CITY OF ALBUQUERQUE

**Re: Pasadena Office Warehouse
Grading and Drainage Plan
Permanent CO – Not Accepted
Engineer's Stamp dated: 7-14-14 (B18D019)
Certification dated: 2-5-15**

GRADING & DRAINAGE PLAN

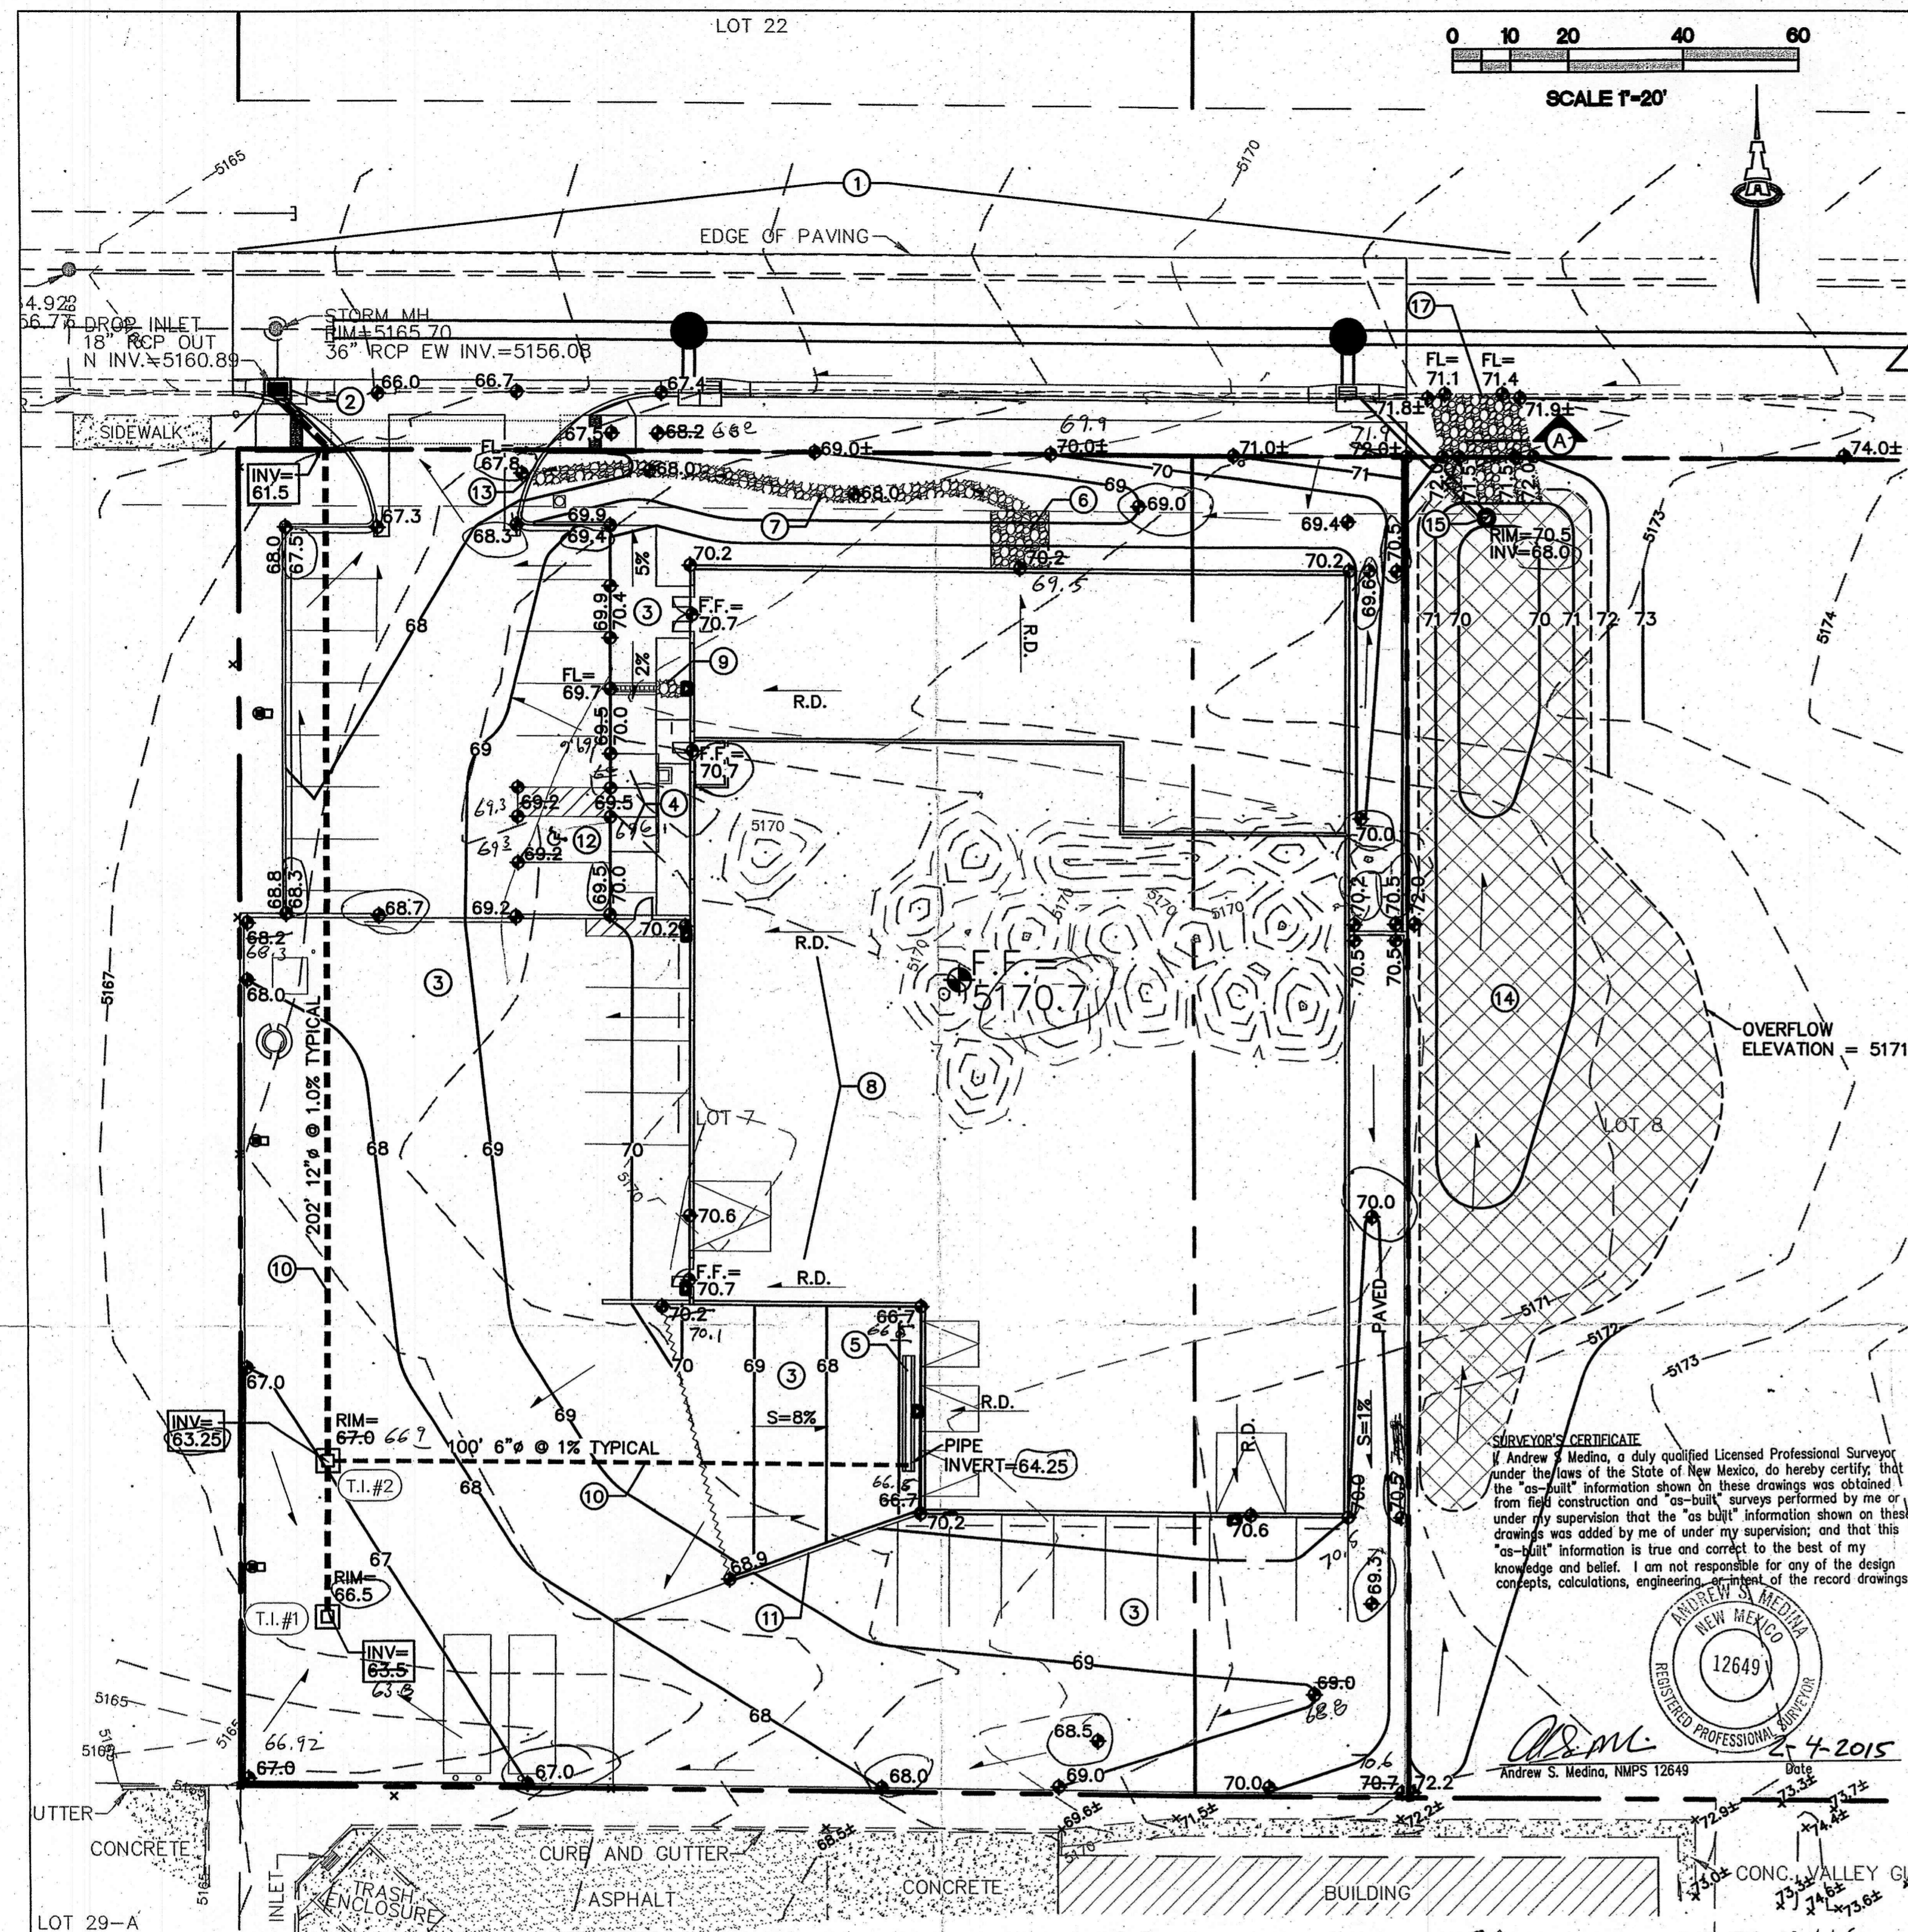
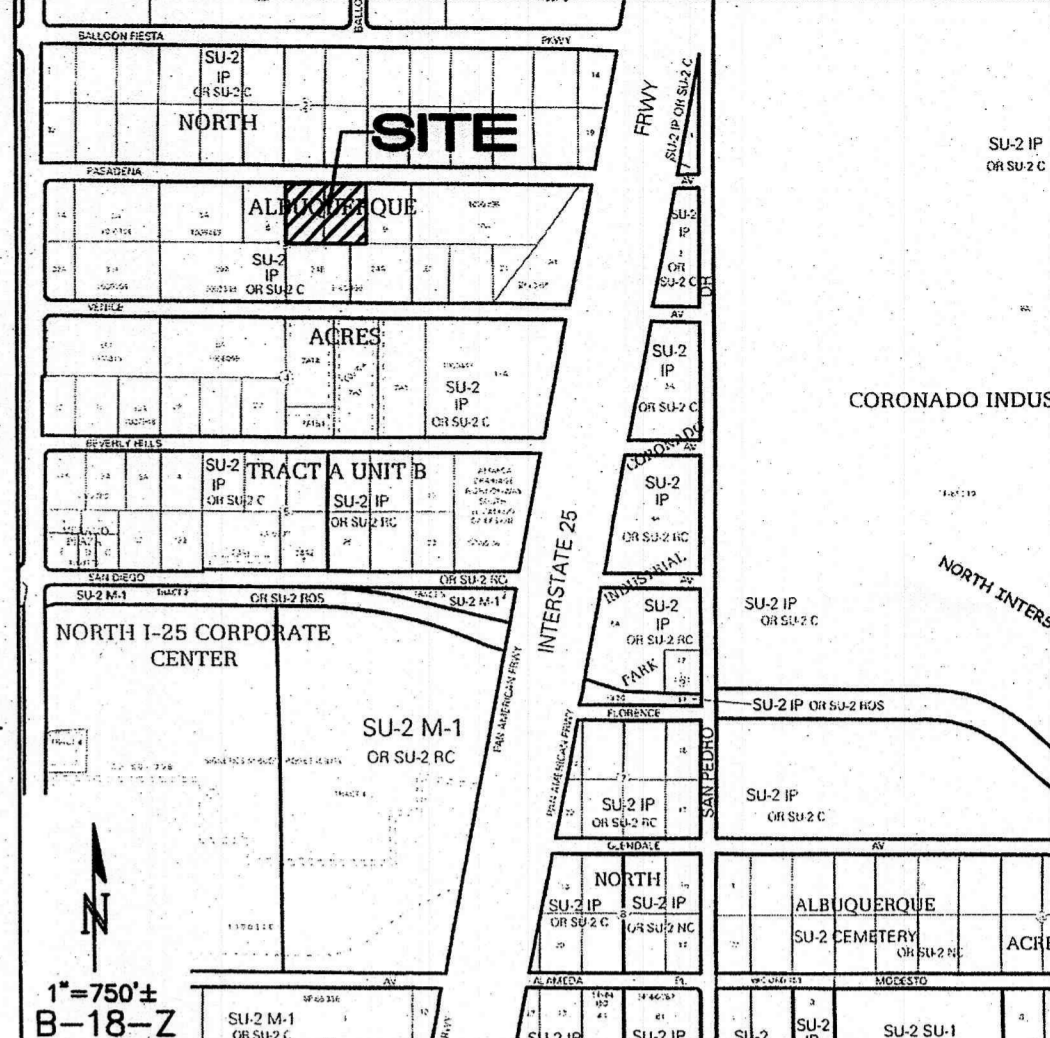
- The inlet at the pond was not placed in the location shown on the plans and was not adjusted for the height specified or the dome put in place.
- Verification that the storm drains in Pasadena Ave NE have been constructed and are acceptable.
- The sidewalk culvert is not placed in the same location as shown on the plans, is this acceptable?
- A sidewalk was built in the northern pond with two 6" pipes placed underneath. Will these pipes be sufficient enough to allow the pond to drain into the parking lot through the proposed 2 foot curb opening?
- The curb opening mentioned above is not 2 feet. It appears to be only 6-8 inches in width. Is this width sufficient enough for the pond to drain?
- The rock protection on the north side of the building was not in place.
